Application Ref:	3/2026/0503			 Ribble Valley Borough Council www.ribblevalley.gov.uk
Date Inspected:	N/A	Site Notice:	N/A	
Officer:	AR			
DELEGATED ITEM FILE REPORT:				APPROVAL

Development Description:	Certificate of Lawfulness for proposed solar panels.
Site Address/Location:	The Stables Whitewell Road Cow Ark Clitheroe BB7 3DG

PL00.02 - Garage: Proposed plans + elevation

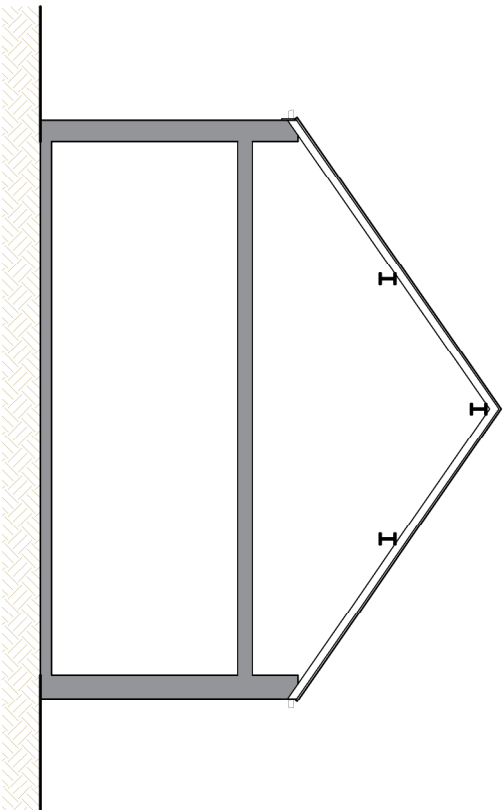
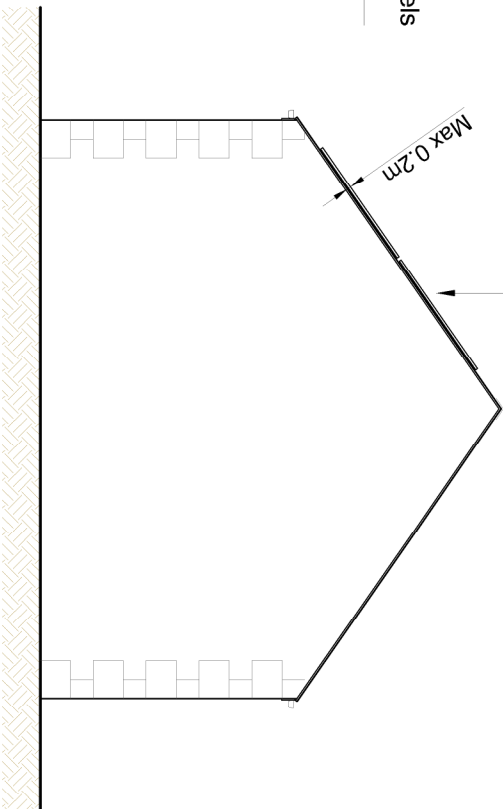
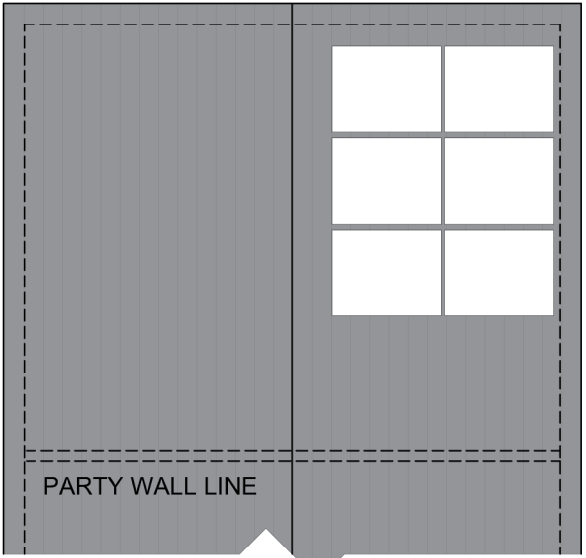
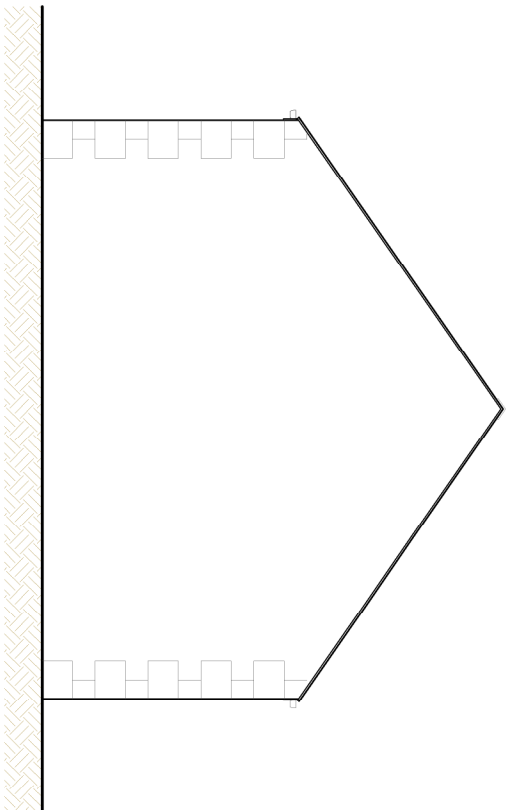
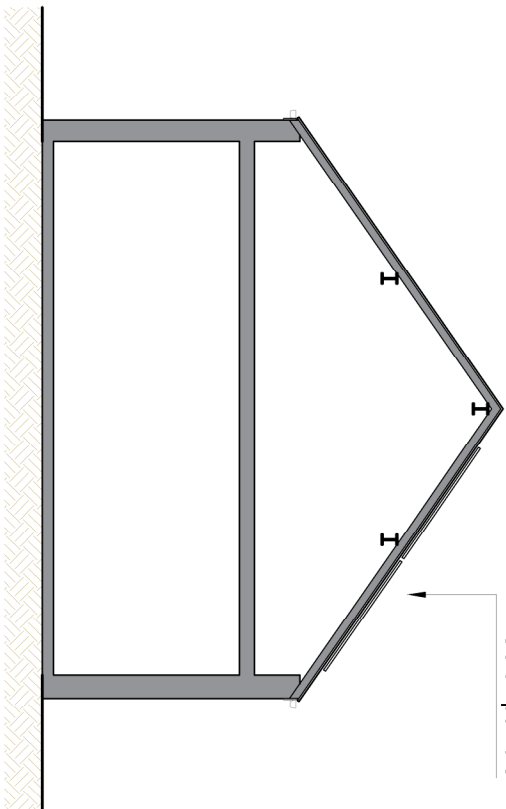
Consent is sought for a Certificate of Lawfulness for the proposed installation of 6 solar panels on the south-western facing roof slope of the detached garage of the Stables.

The proposed solar PV would not protrude more than 0.2 metres beyond the plane of the wall or in the case of a pitched roof, the roof slope when measured from the perpendicular with the external surface of the wall or pitched roof slope.

The proposed solar PV would be situated on a pitched roof and would not result in the highest part of the solar panels being higher than the highest part of the roof (excluding any chimney).

The proposed works shown on 'Garage: Proposed plans + elevation' ref: PL.00.02 0145, and 'Existing + Proposed Site Plans' ref: PL.00.04 0145, constitute permitted development under Schedule 2, Part 14, Class A of the Town and Country Planning (General Permitted Development) (England) Order 2015 (as amended), subject to the solar PV panels being removed as soon as is reasonably practicable when no longer needed.
